Development Control
Ribble Valley Borough Council

App no: 23.0634

Address: Primrose House Primrose Road Clitheroe

Proposal: Planning permission for proposed single-storey self-build dwelling with associated car port, parking and manoeuvring space, refuse storage, garden area, hard and soft landscaping, to be accessed via the Old Cotton Mill access following removal of a section of boundary wall

Nova, Primrose Road, Clitheroe, BB7 1BS

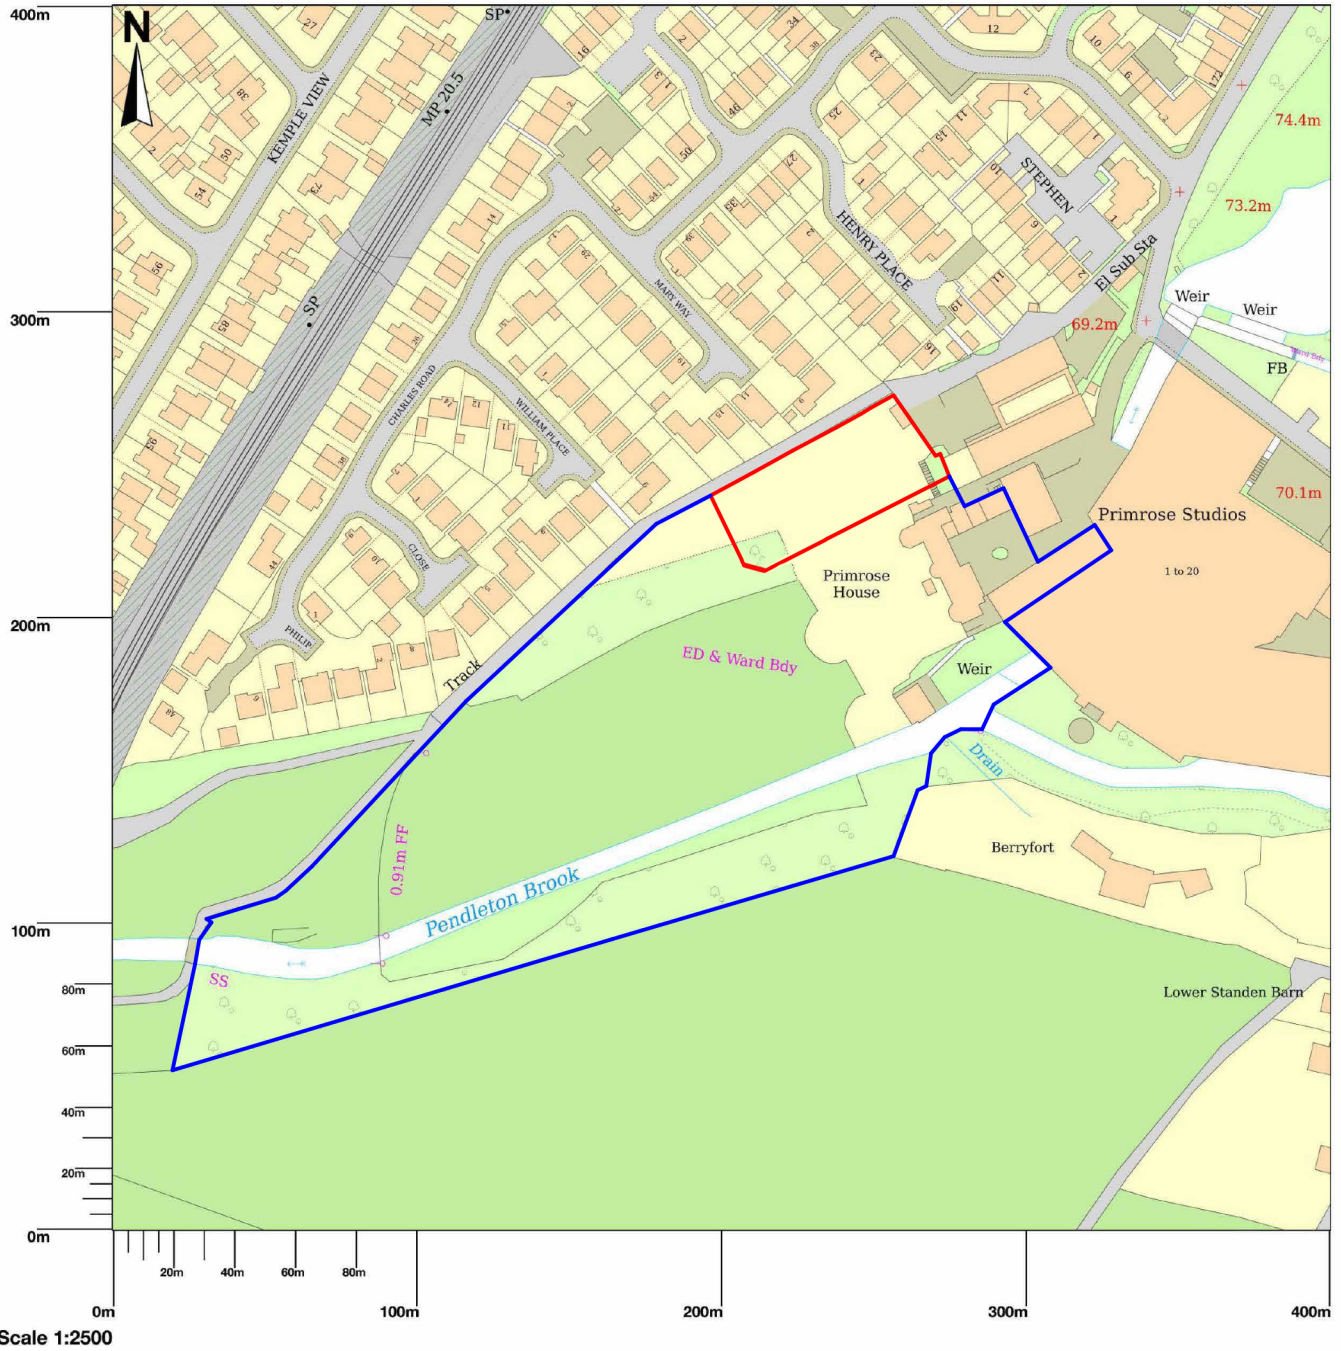
The Old Cotton Mill car park and private road are not within the red or blue edges on the location plan.

The creation of the new access within the car park will result in the loss of 2 parking spaces marked '15' and 'V', which refer to apartment 15 and visitor. This is not within the red or blue edges and further information is requested to identify the ownership and management of these spaces and where the car parking spaces will be displaced to.
